SPACE VILLAGE FILING No. 3 PRELIMINARY PLAN

A COMMERCIAL SUBDIVISION LOCATED IN SECTION 17, TOWNSHIP 14 SOUTH, RANGE 65 WEST OF THE SIXTH PRINCIPAL MERIDIAN, COUNTY OF EL PASO, STATE OF COLORADO

DATE: 09/08/2017
SHEET NUMBER: 1 OF 1

SPACE VILLAGE FILING No. 3  
PETERSON BOULEVARD & SPACE VILLAGE AVENUE  
PRELIMINARY PLAN

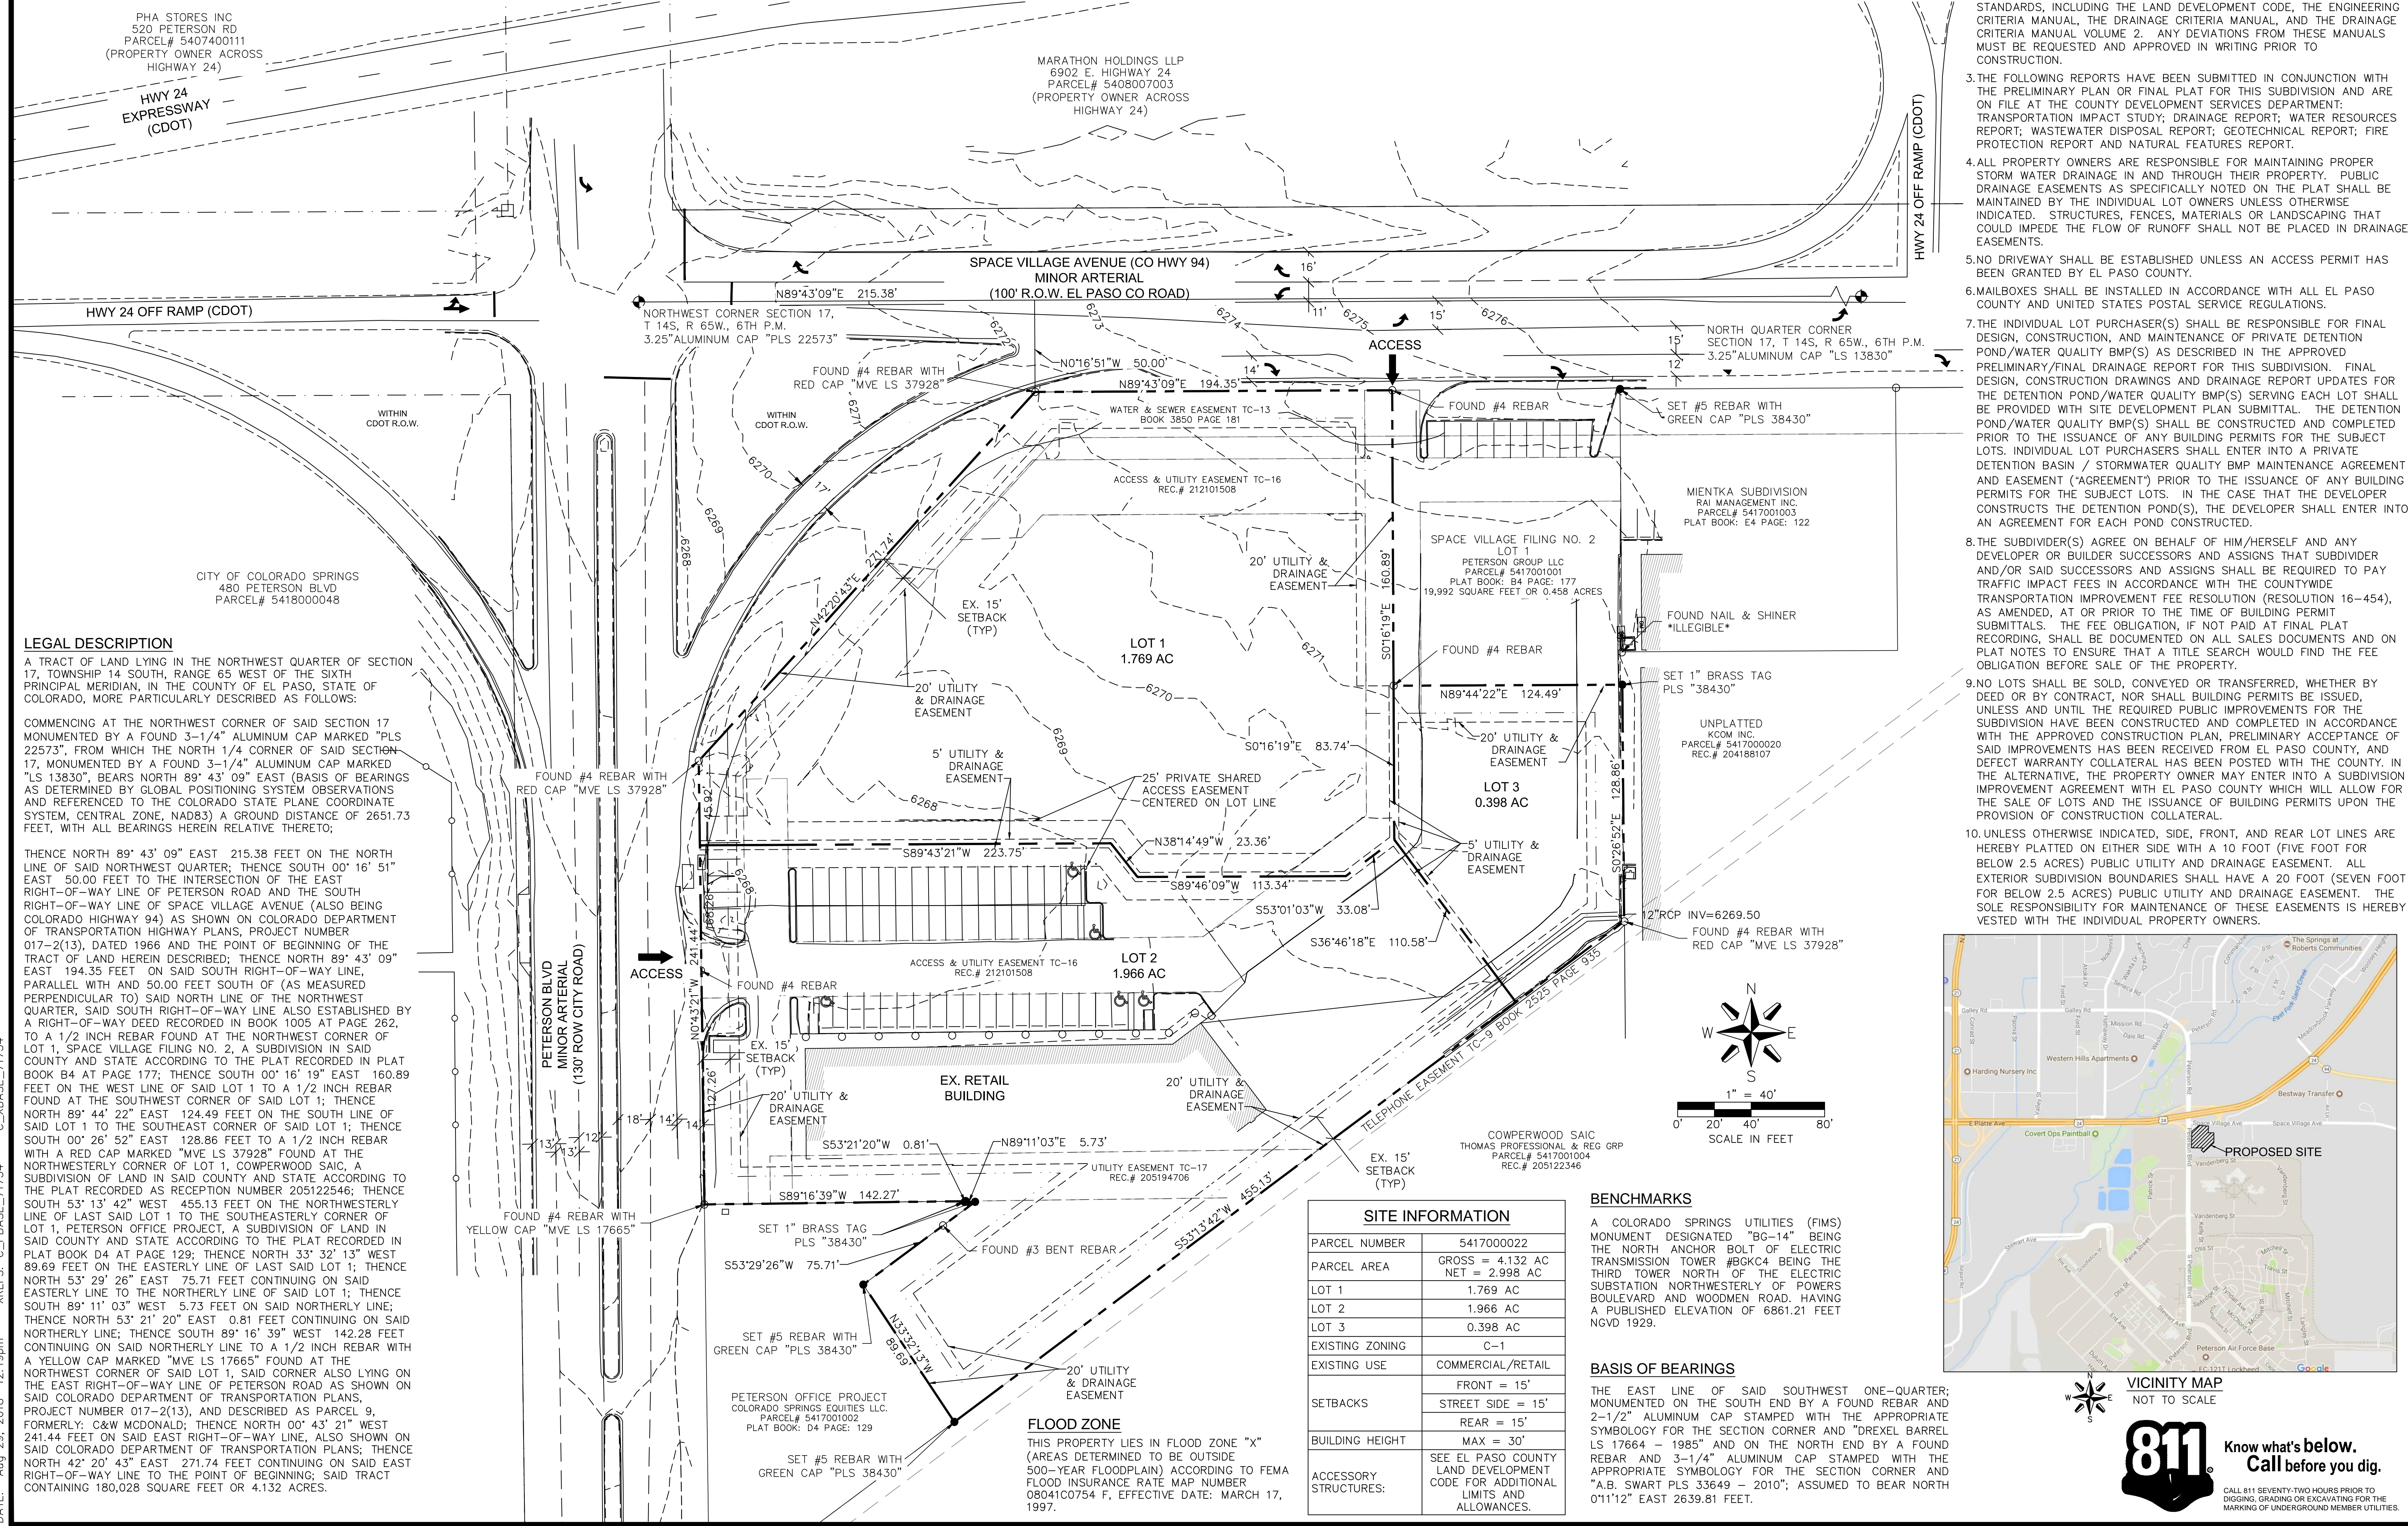
Label the street name and identify as CDOT

Show the existing and proposed line work in greater detail and include dimension labels identifying lane widths.

Per the Traffic Study the (2) 50' left turn lane should be located to the east at the US-24 access and a proposed westbound left-turn into the north drive was recommended. Adjust the linework accordingly.

Label the street and identify as CDOT

Proposed improvements to City or County streets must be approved by these jurisdictions.

Approval from CDOT/Colorado Springs?

Show the proposed improvements on the preliminary plan.

Submit street construction plans with the site plan application for the proposed modification to Space Village Ave.

Identify as El Paso County road.

Identify as City road
